| DECISION DELEGATED TO HEAD OF PLANNING |

| Application No: | H14-0200-23                                            | Applicant: | Mr T Rogers |
| Proposal:       | Alterations, extension and widening of existing access |            |             |
| Location:       | The Old Farmhouse Money Bridge Lane Pinchbeck          |            |             |

GROUND FLOOR PLAN

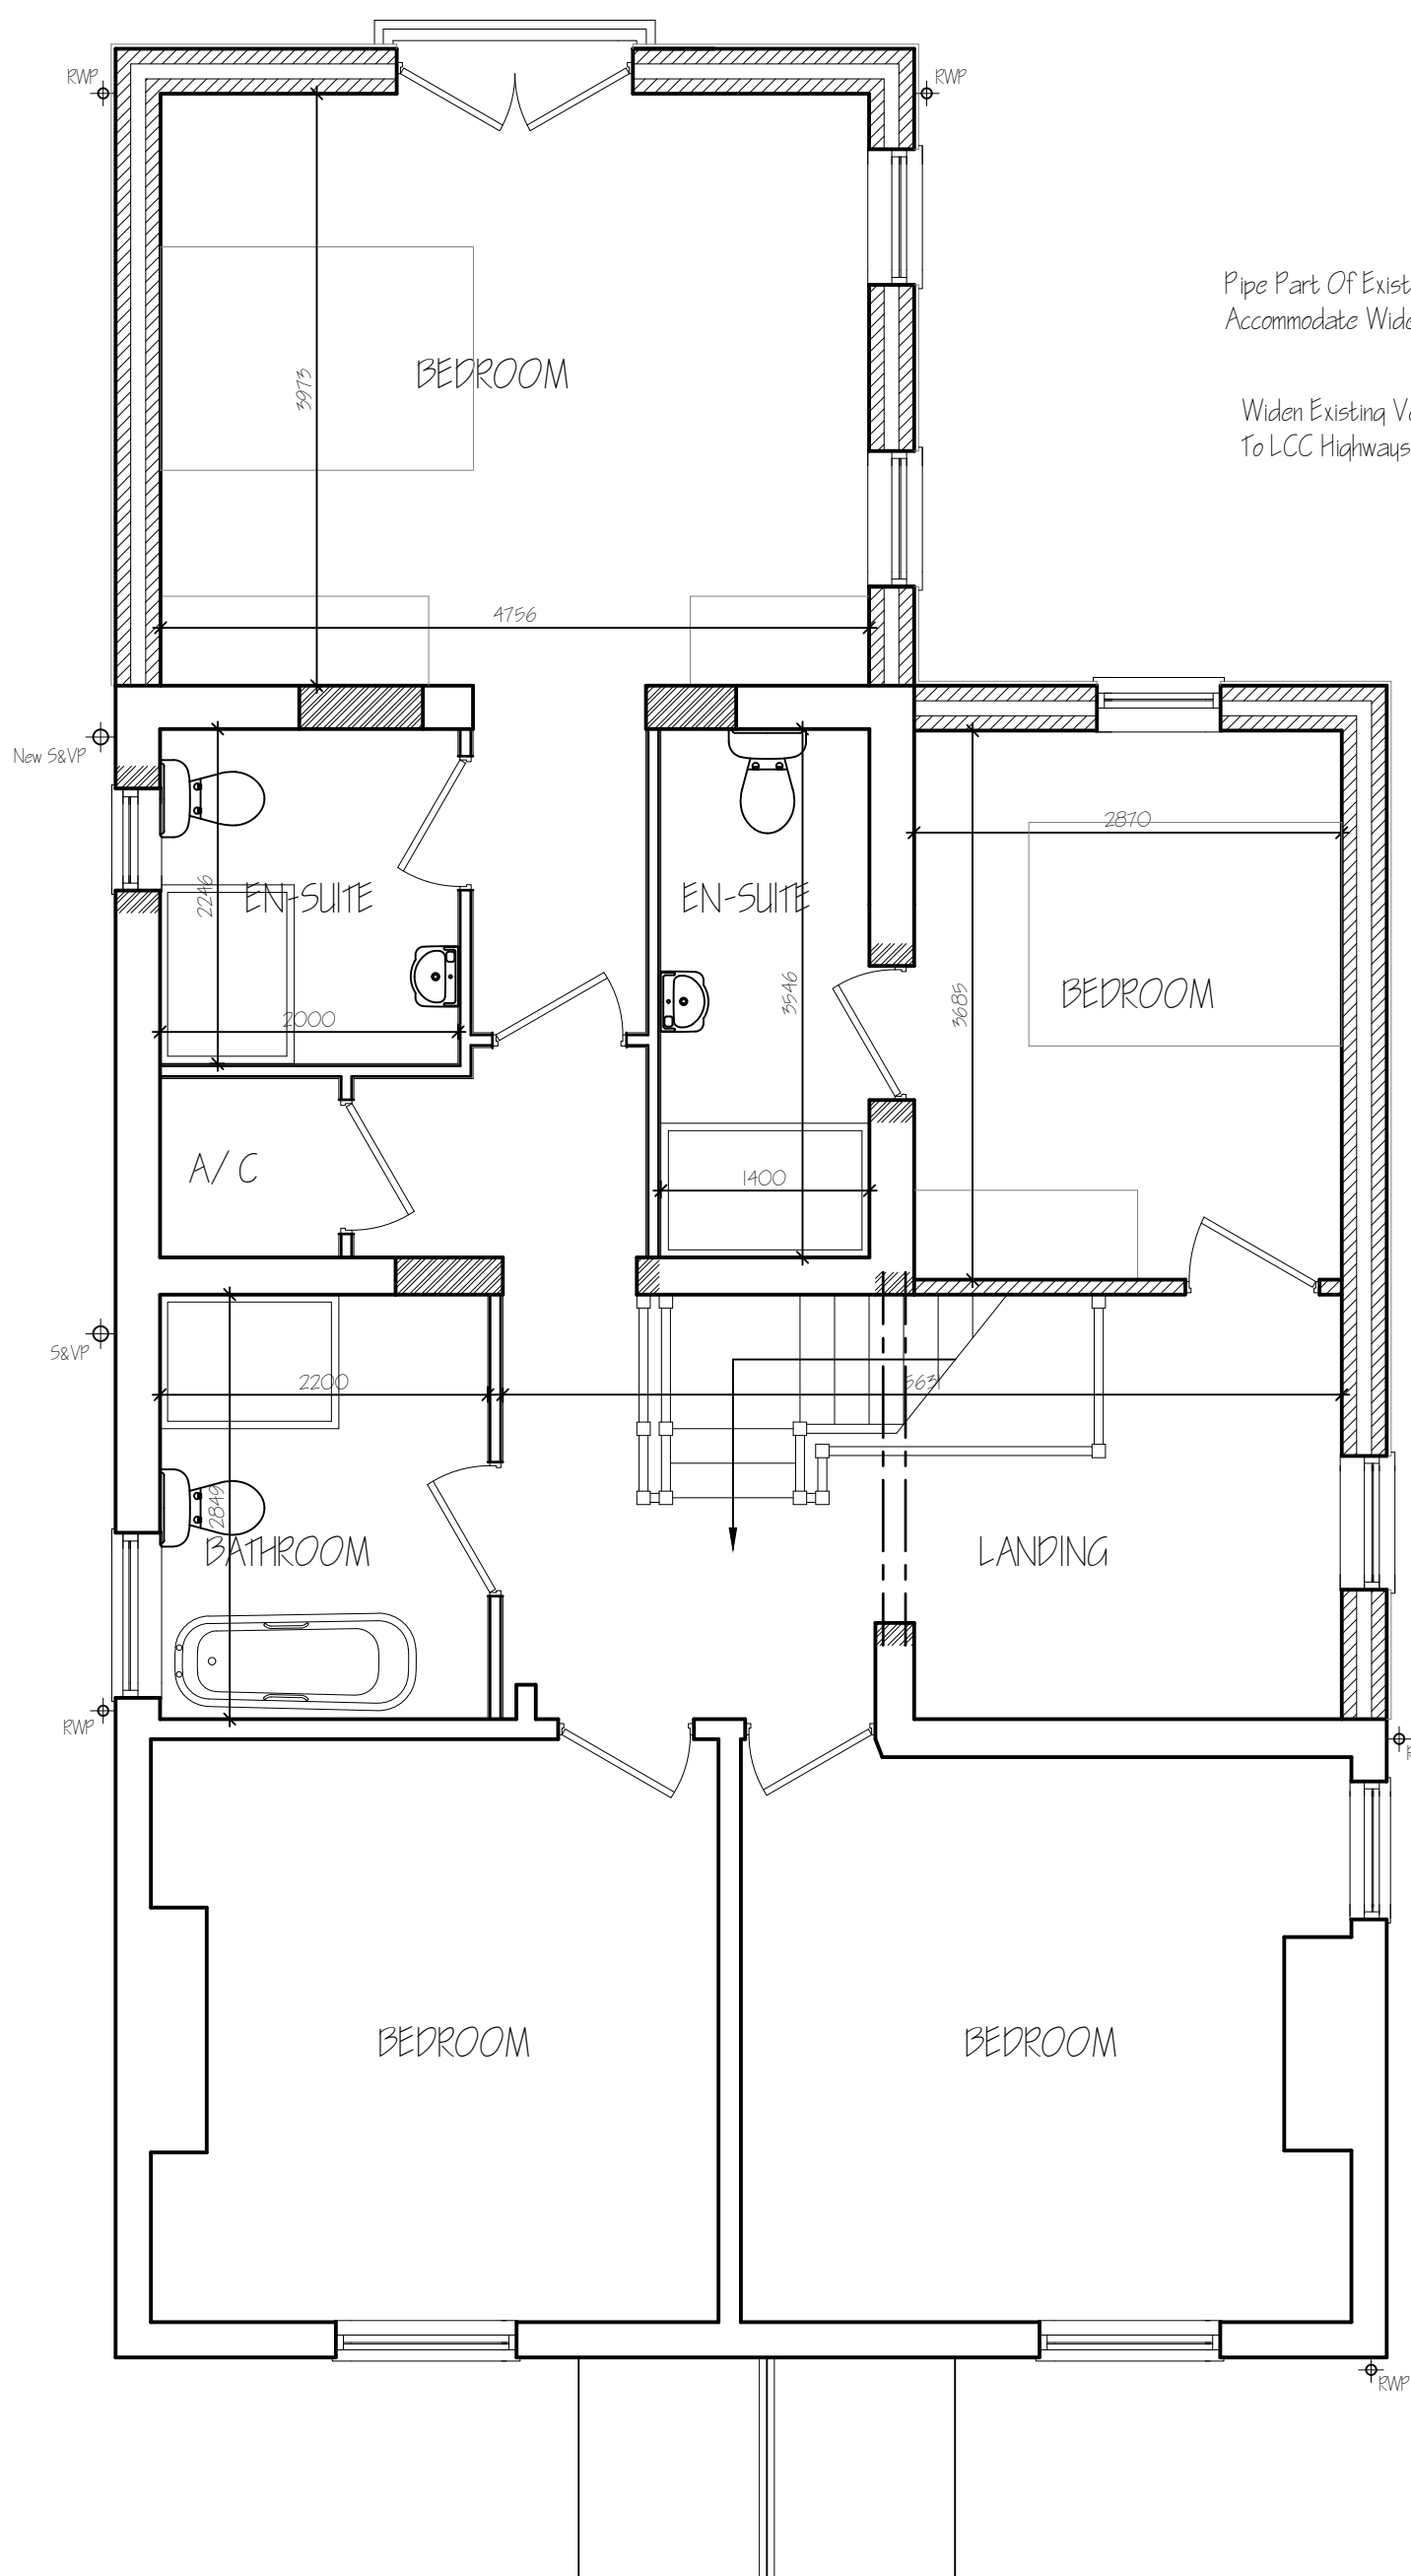
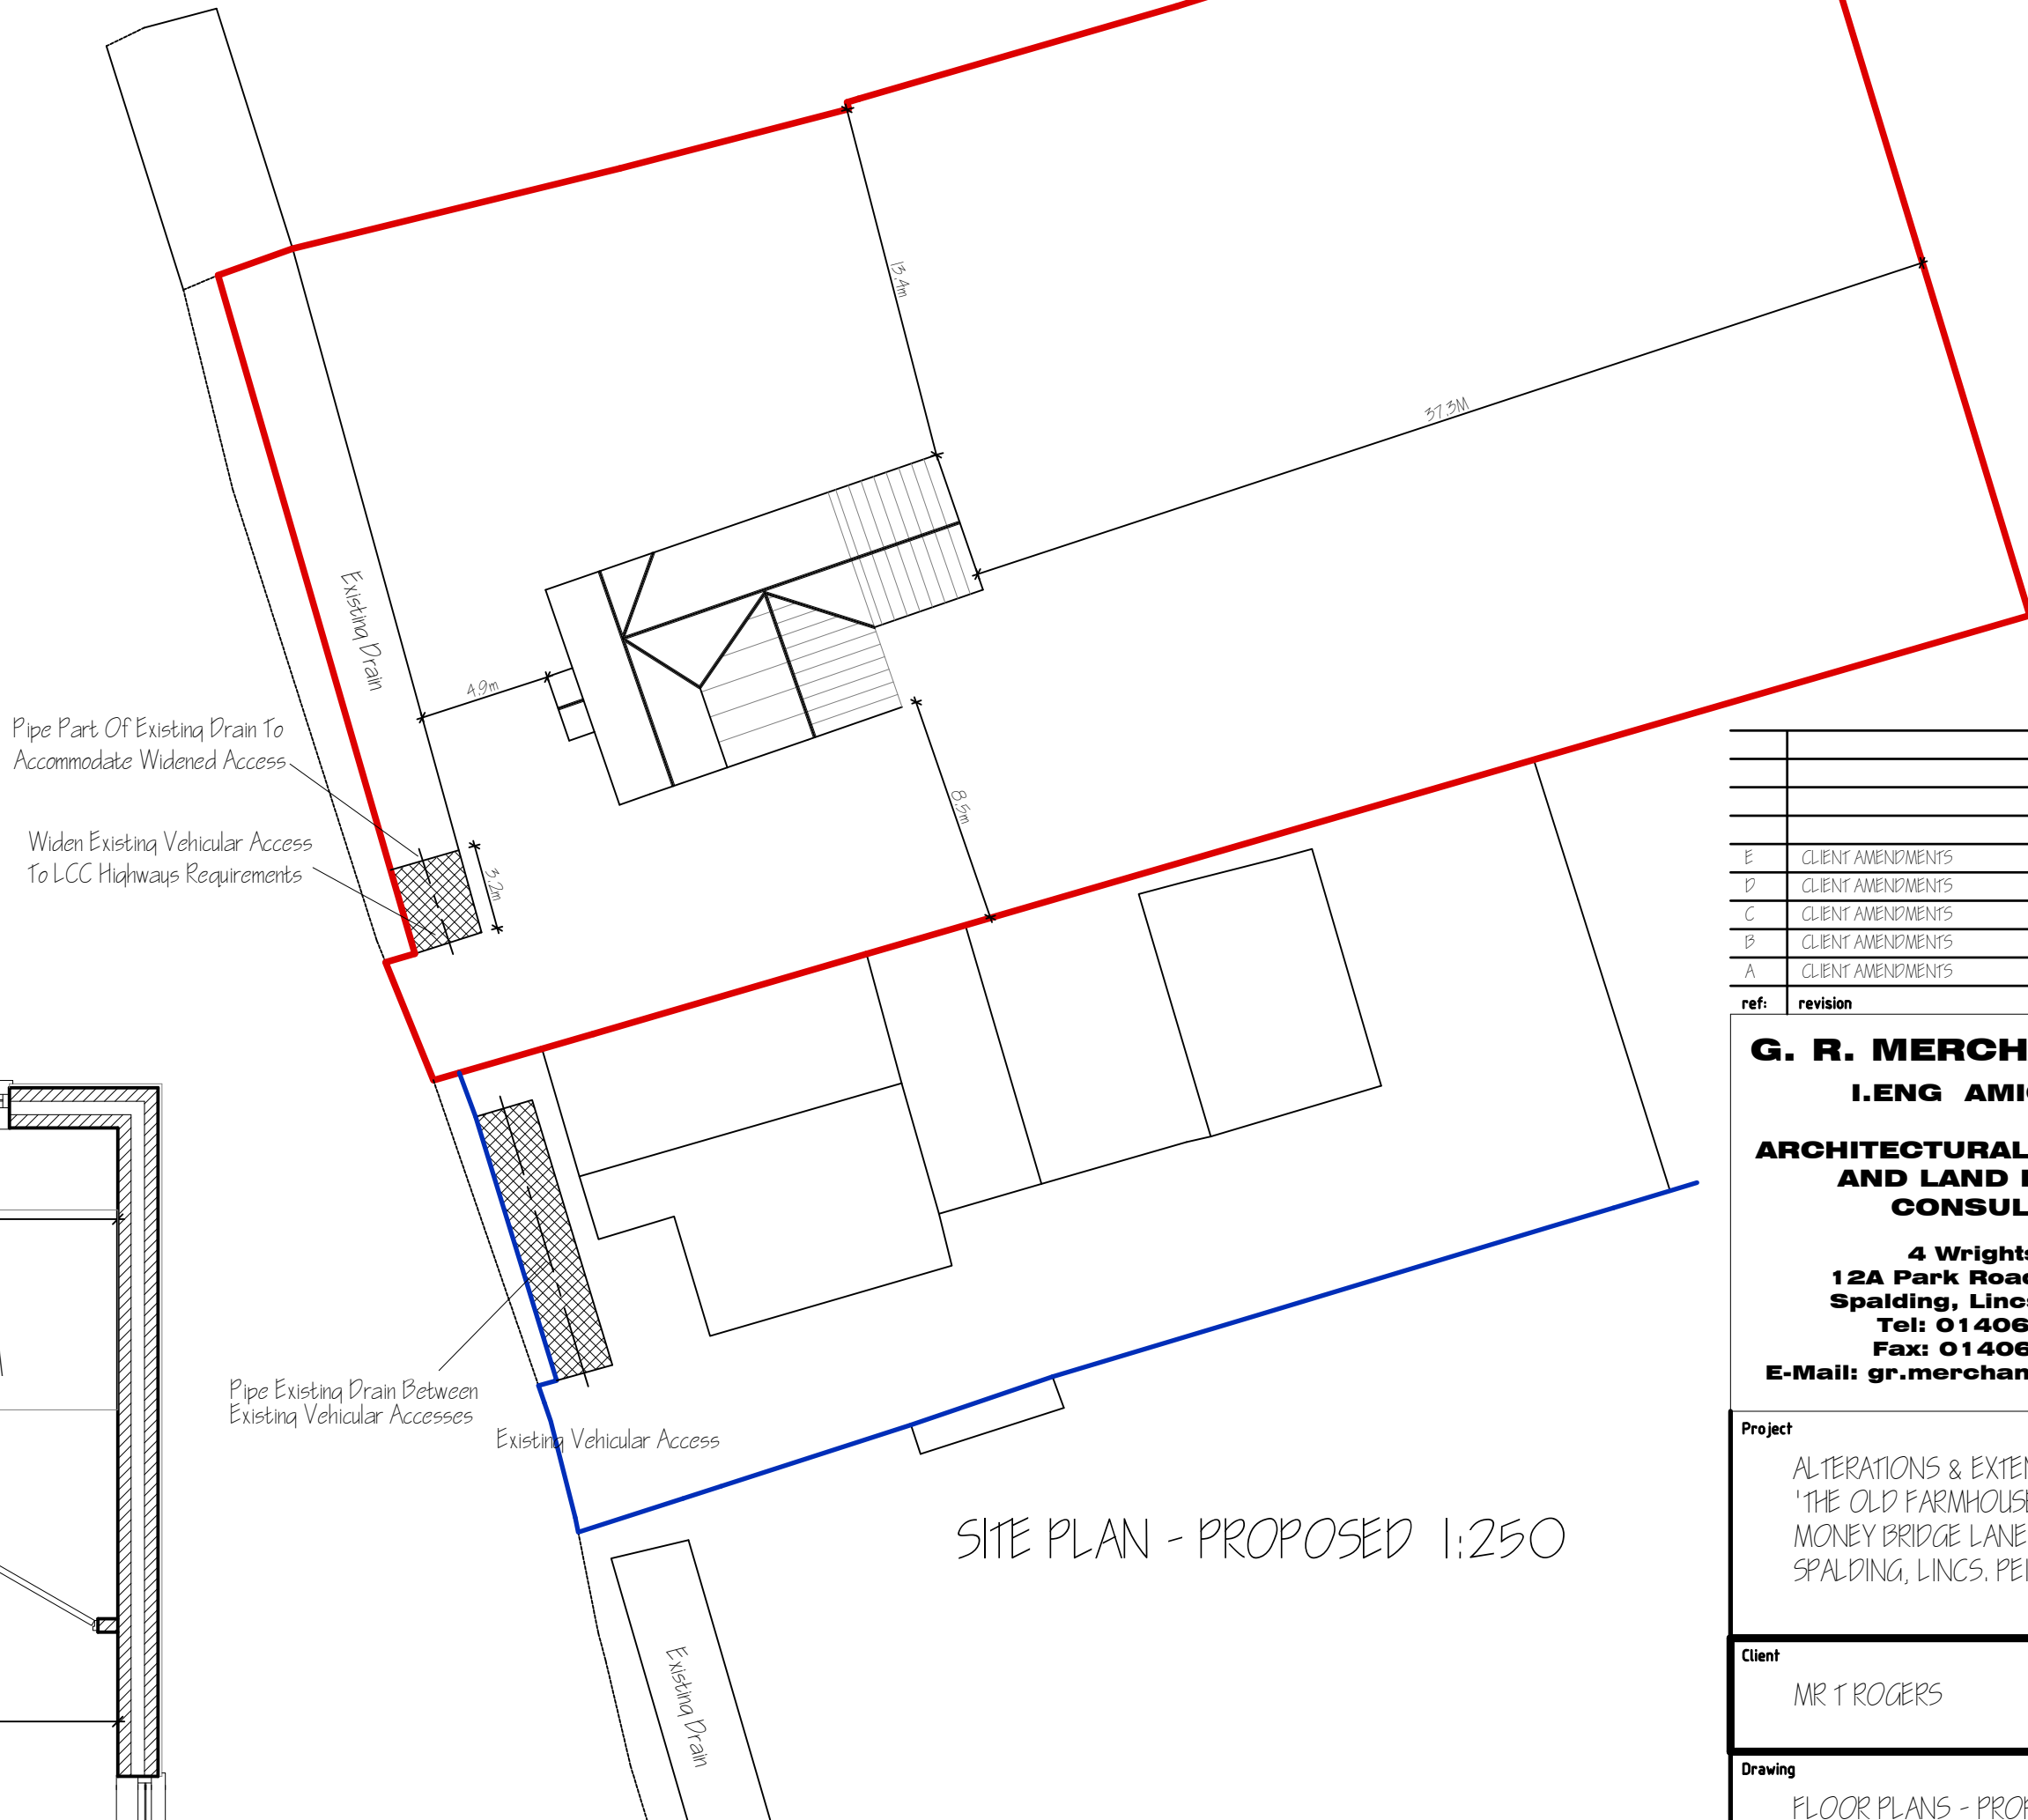
Regarding the extension, that is not a problem, my only concerns are that the relevant Drainage Board has not been asked to give comments and advice on the application to pipe and fill 2 sections of drain at the front of the property which must be done to their standards. I am also unsure why a domestic property needs to widen its access to such an extent.

With regards to the proposed widening of the existing access this is not considered to unacceptably impact the appearance of the street scene on Money Bridge Lane.

The proposed widening of the access on Money Bridge Lane is not considered to result in any unacceptable impact on neighbouring amenity as all activities/traffic would be associated with the existing dwelling on the site.

Representation has been received raising concerns with the need for the widening of the access. This concern was address with the agent and clarification was received. The main reason for widening the access is to give better access and egress for the horses and paddocks behind with regard to larger vehicles for transportation and feed deliveries.
